**Our ref:** 25\_31414\_P

**Your ref:** H23-0313-25

**Site Location:** Land At Peartree Hill Road  
Whaplode Drove Spalding PE12 0SL

**Summary of Proposal:** Provision of new  
poultry unit & associated works

PROPOSED:
Provision of New Poultry Unit & Associated Works
Proposed Access Plan and Visibility Splay

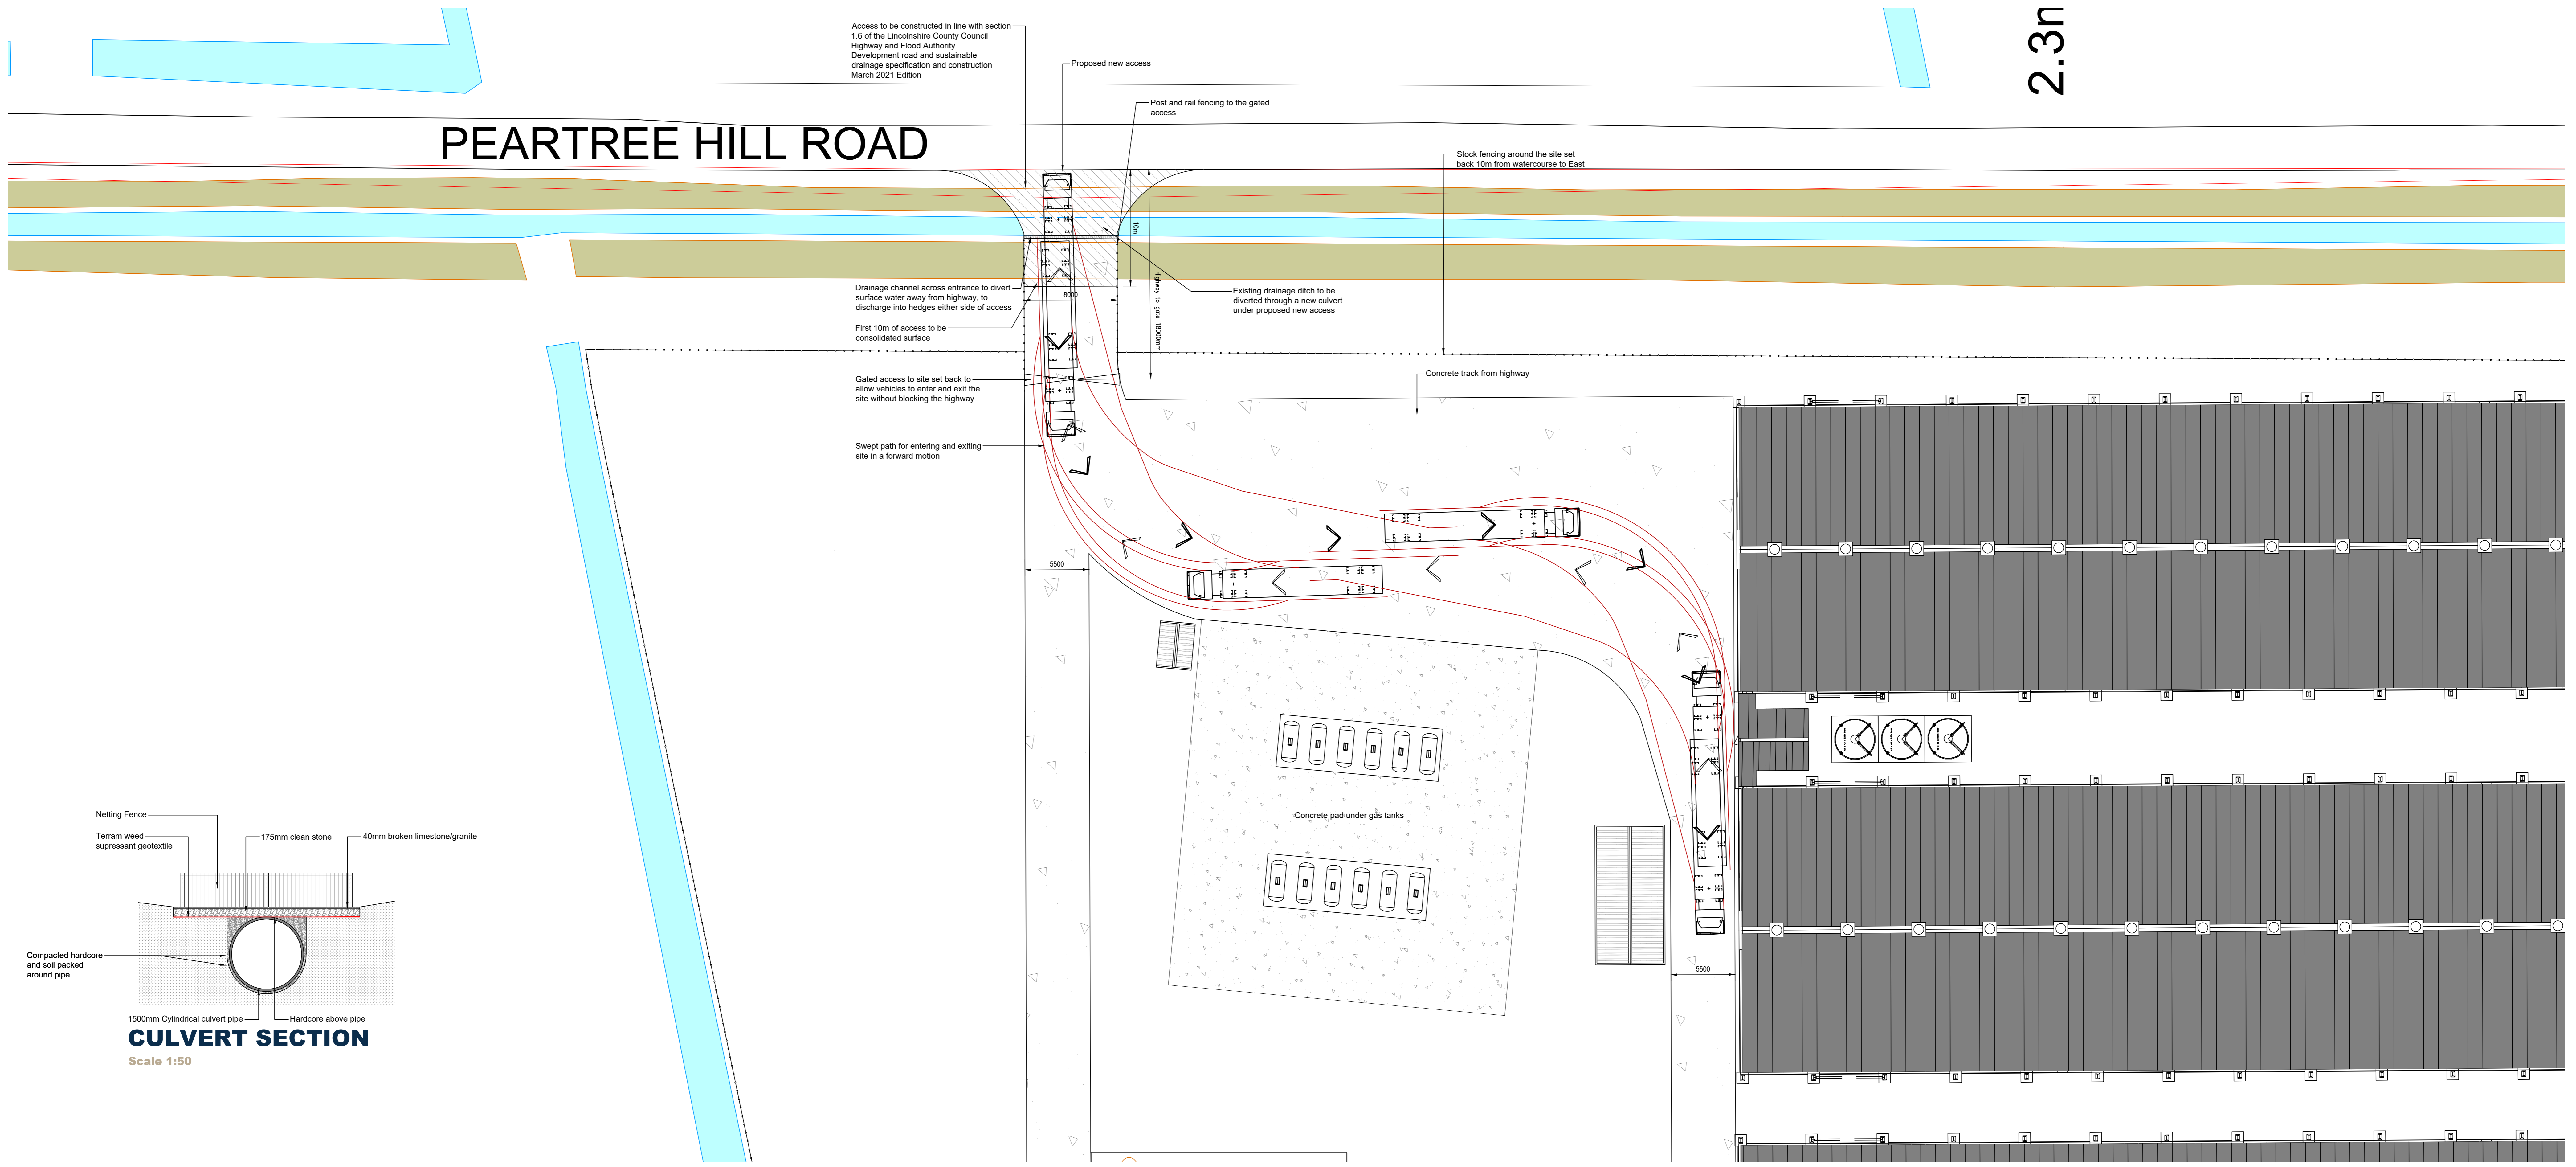
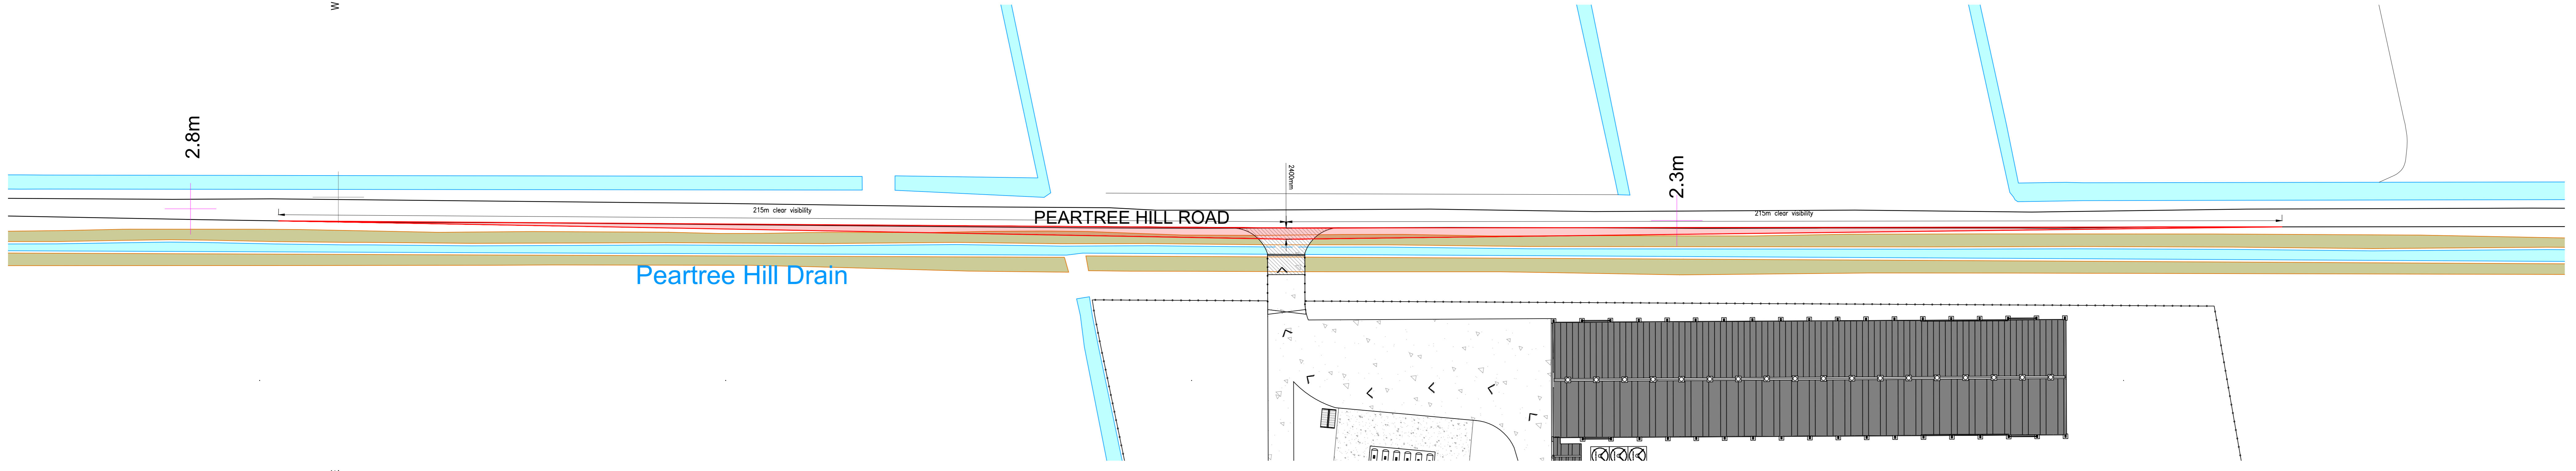
Within the drawing Proposed Access Plan and Visibility Splay 'JW/2384/0325-200\_04 Rev A' (Acorus, 17.08.25), we are pleased to see that the applicant intends to construct the proposed poultry units and concrete track further than 9 metres from the brink of the Board owned arterial watercourse. I can also see that boundary stock fencing is proposed to be installed 10 metres from the brink of the Board owned arterial watercourse. In light of this, the Board removes its objection. **Please note, the Board's 9 metre Byelaw zone is measured from the brink of the watercourse (where the slope of the drain meets the flat land) landwards.**

Also within the aforementioned drawing, I can see that the applicant proposes to install post & rail fencing on top of the proposed entrance access culvert and that a new drainage channel and surfacing are proposed to be constructed within 9 metres of the Board owned arterial watercourse. **To enable this proposal, consent would be required under Byelaw 10, and I recommend that the applicant contacts this office to make an application for this consent at their earliest convenience.**
